**KIRKLEES METROPOLITAN COUNCIL
INVESTMENT & REGENERATION SERVICE**

DELEGATED DECISION TO DETERMINE PLANNING APPLICATIONS

Reference No:	2023/62/91768/W
Site Address:	land off, Netherley Drive, Marsden, Huddersfield, HD7 6HL
Description:	Erection of 2 dwellings
Recommending Officer:	William Simcock

DECISION - REFUSE

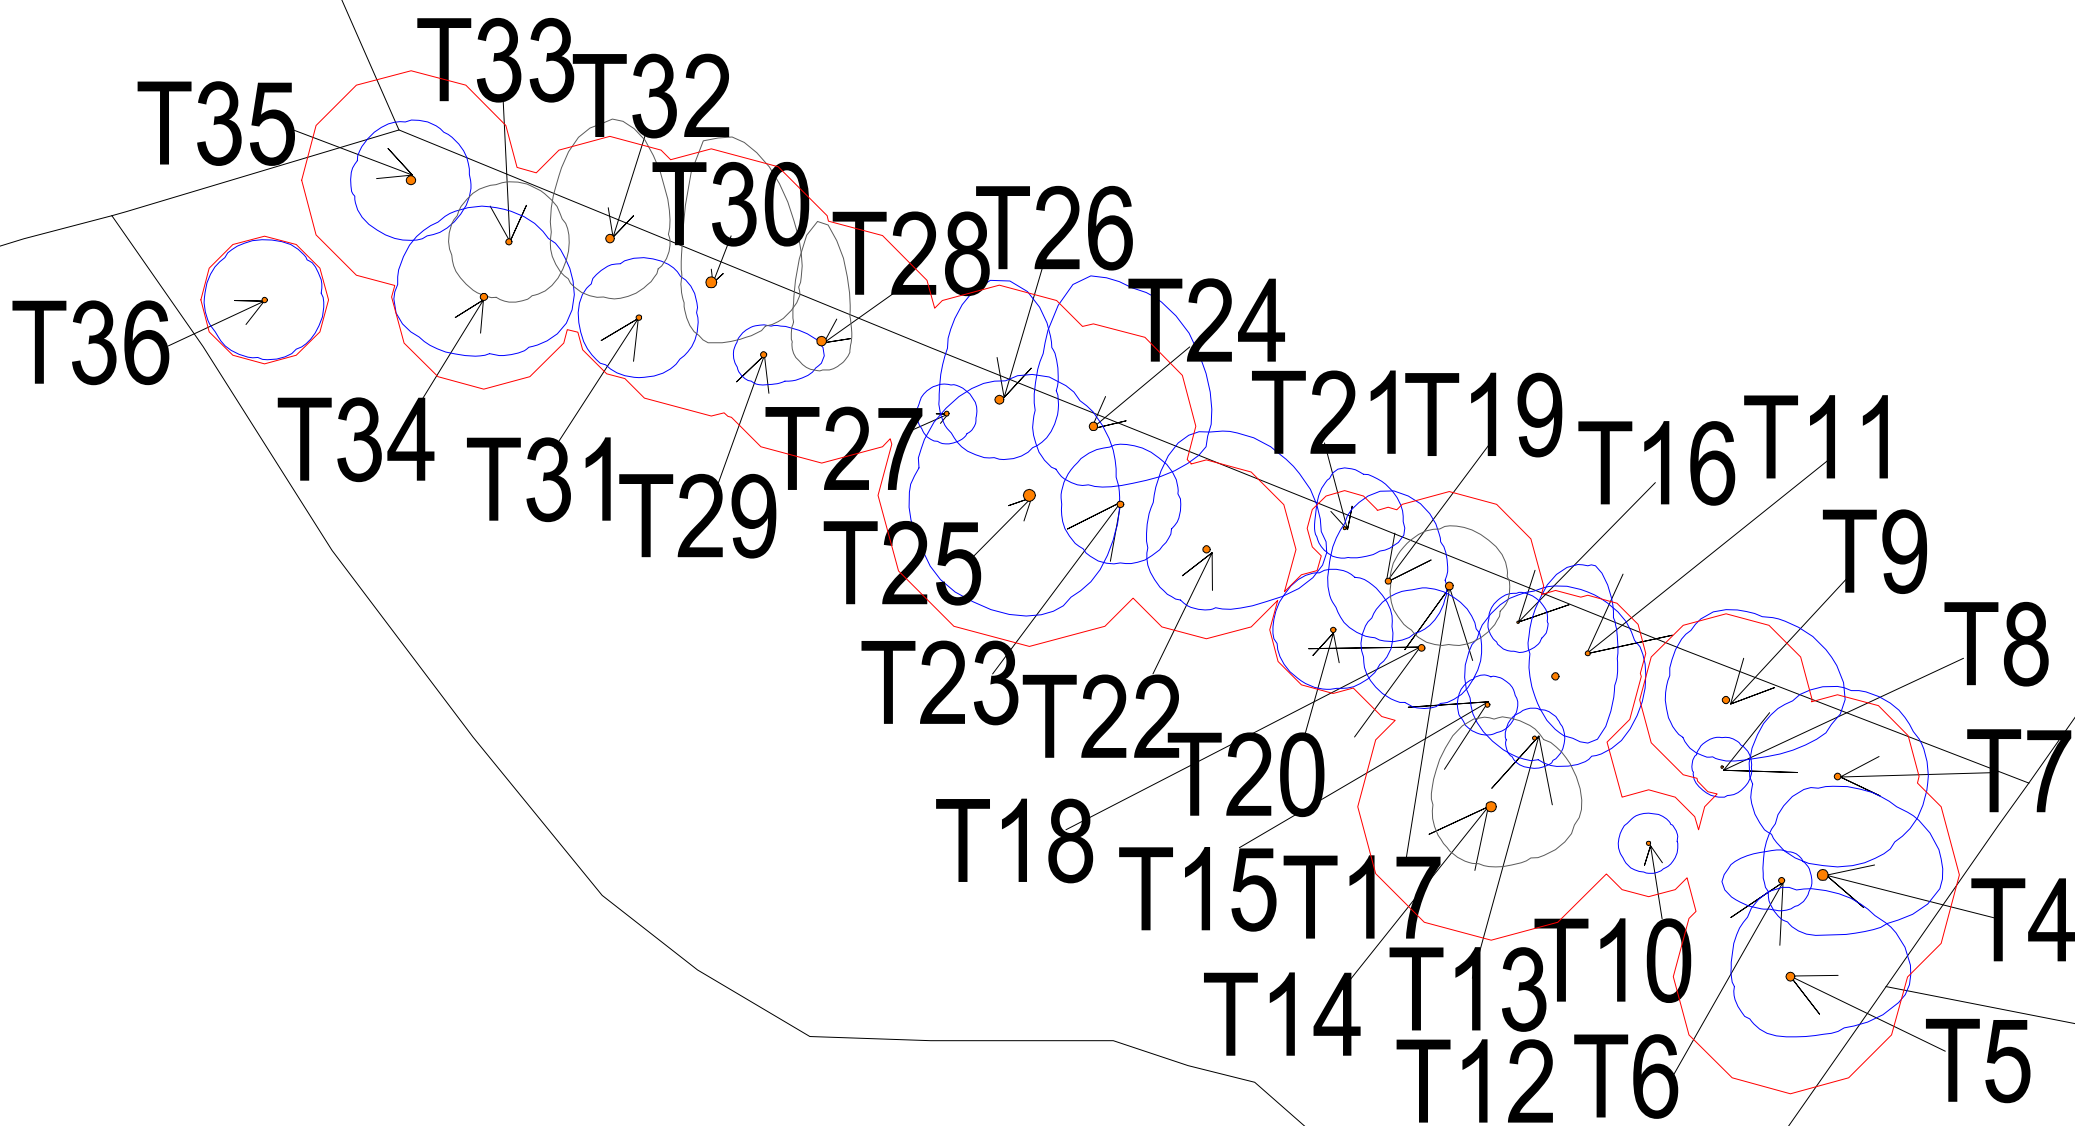
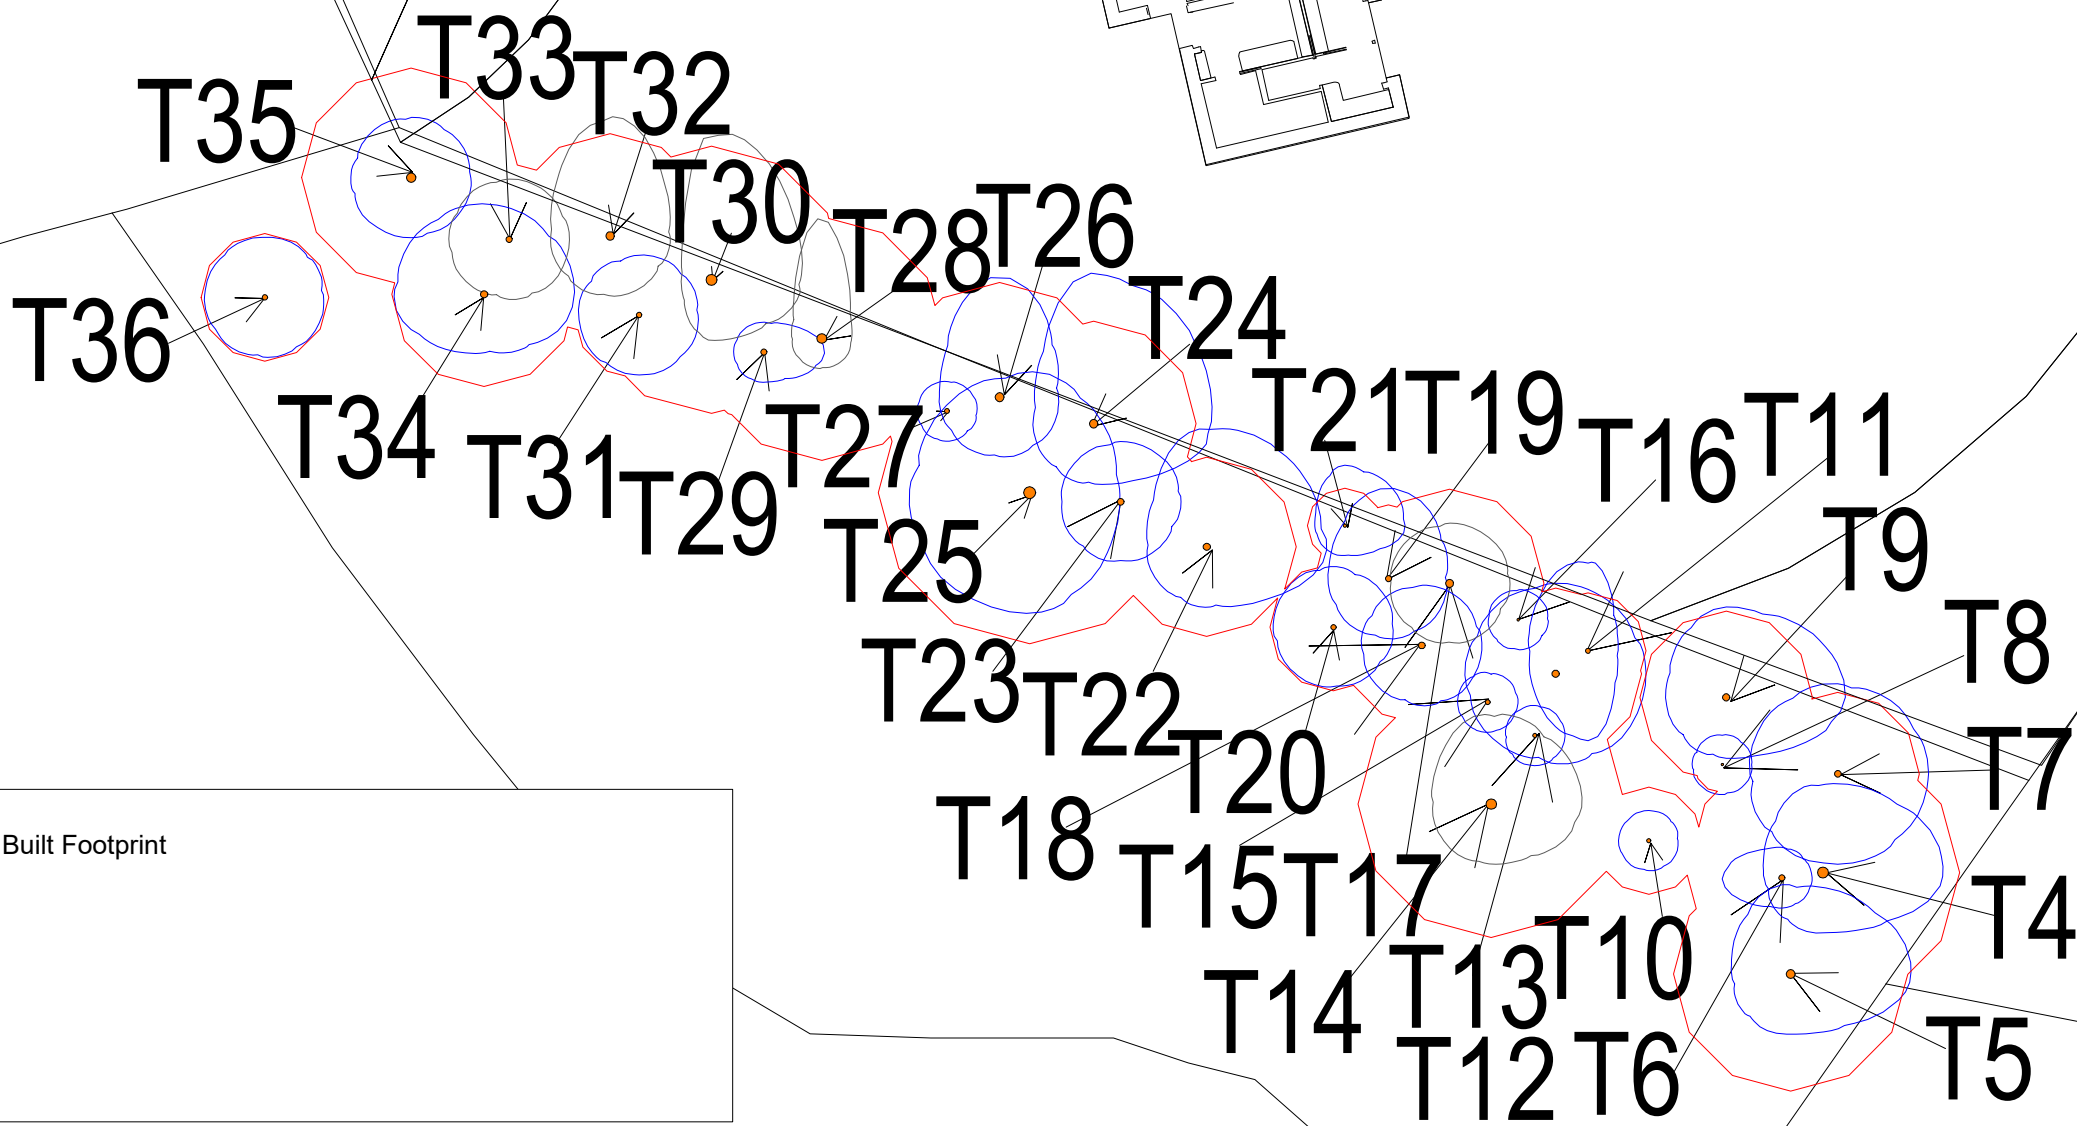
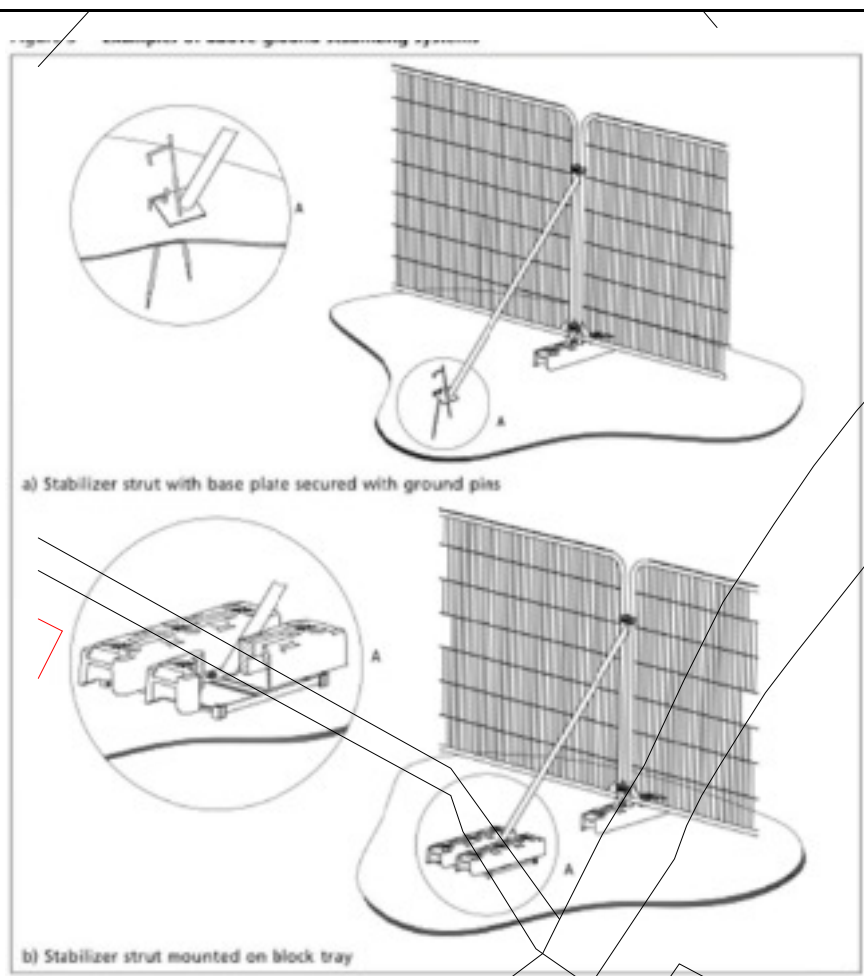
A tree survey and Arboricultural Impact Assessment (AIA) have been submitted. The AIA however, is considered inadequate, in particular, in its assessment of the proposed ground level changes to facilitate plot 2 and the surrounding land that could encroach into the Root Protection Areas (RPA)s of the neighbouring trees.

The position and orientation to the woodland/group of trees along the southern boundary of the site could be perceived as having a negative impact on Plot 2 once occupied (owing to shading, seasonal debris, or fears that their size and proximity would lead to structural issues or damage in the event of failure), which will lead to pressure from residents to prune or selectively remove trees. If a Tree Preservation Order were to be served, the Council’s consent would be required before carrying out such works, but in deciding whether to grant or withhold permission, the Council would have to take into account the presence of the proposed dwelling and the ongoing implications of the trees for its occupants.

# House Type 1 - 1 of 2

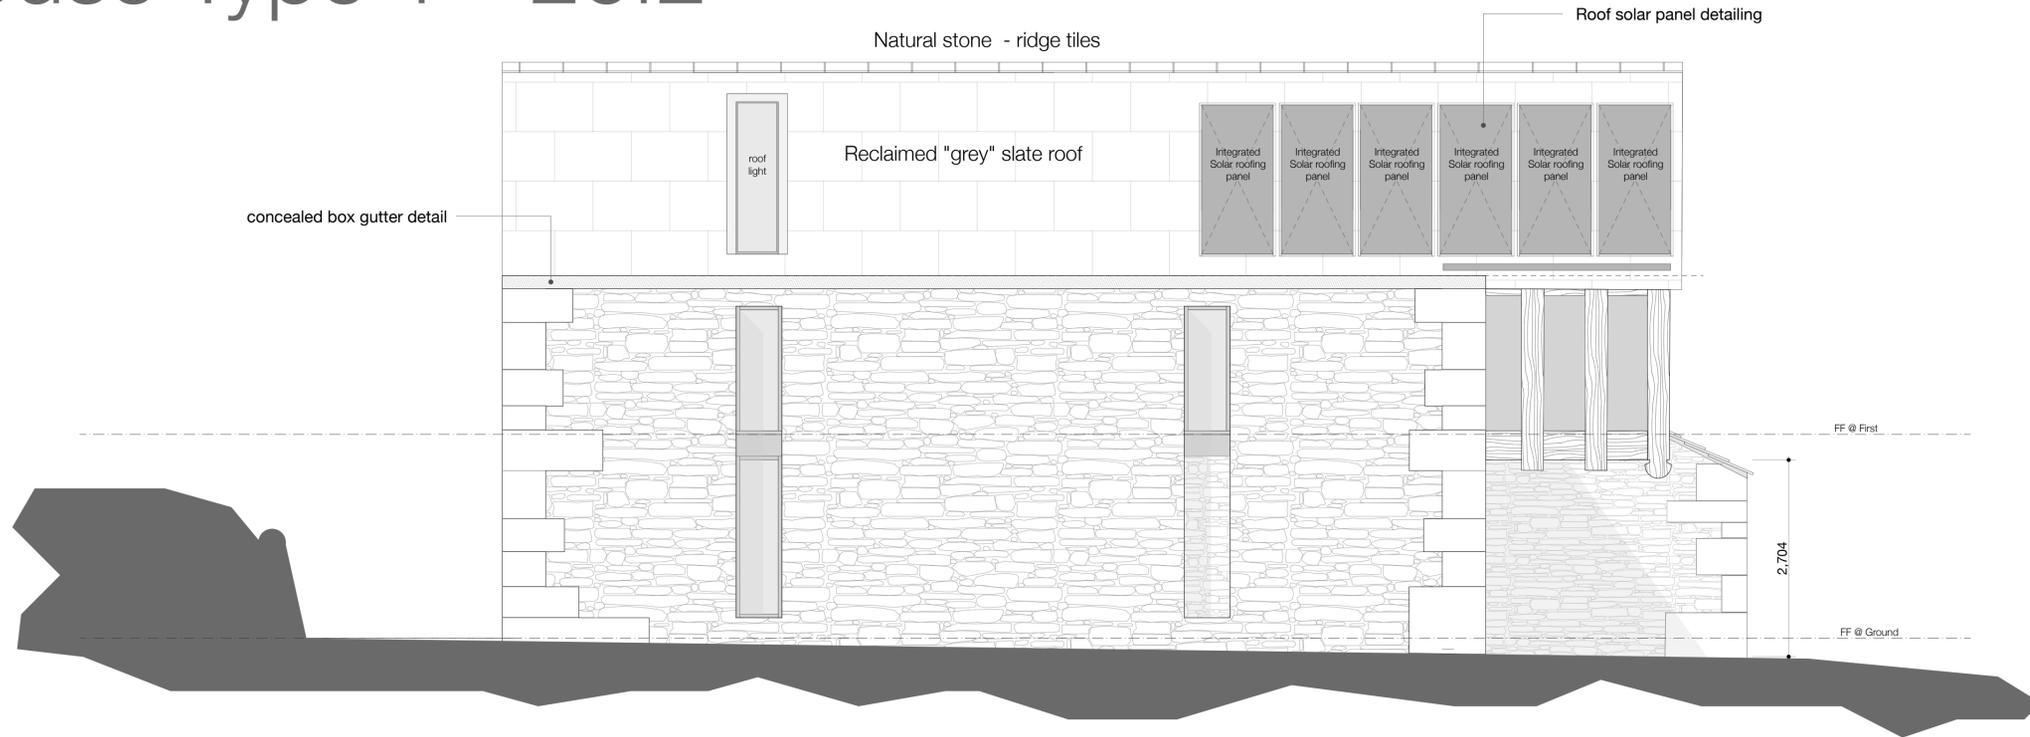
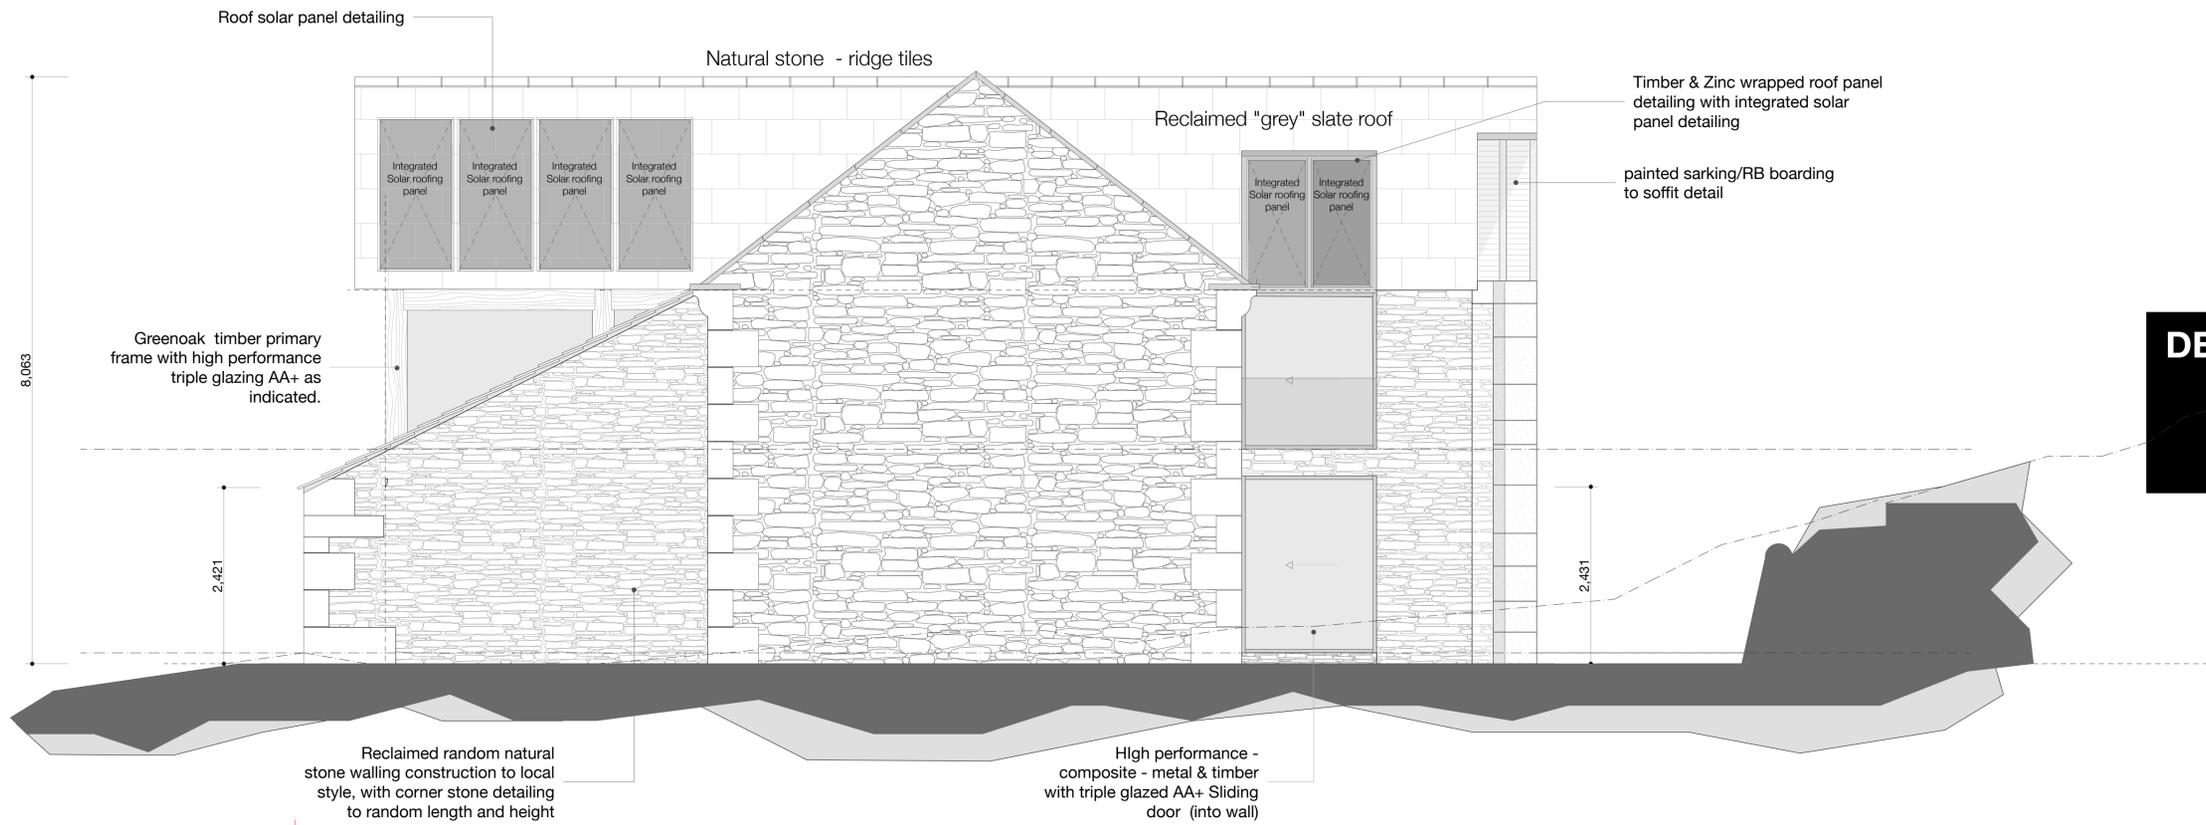
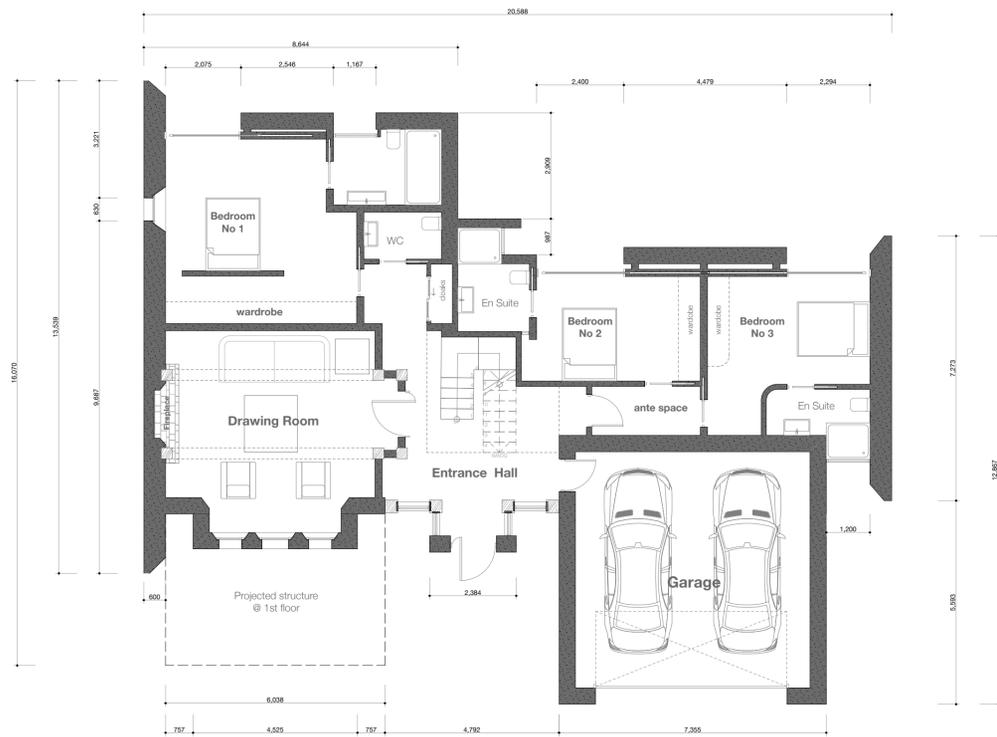
The built form, proportions and design details of the proposed dwellings would bear little relation to the local vernacular. Particularly notable are the use of green oak and glazing, the window proportions (some of which are either exceptionally tall and narrow, or nearly square) and the overhanging first-floor lounge with a void below. The Housebuilders' Design Guide expresses qualified support for the use of “innovative designs”, paragraph 8.3 stating that “Contemporary and innovative approaches will be welcomed where they are of high quality and complement the existing context.” It is considered that the design is of high quality but does not complement the existing context, for the reasons set out above.
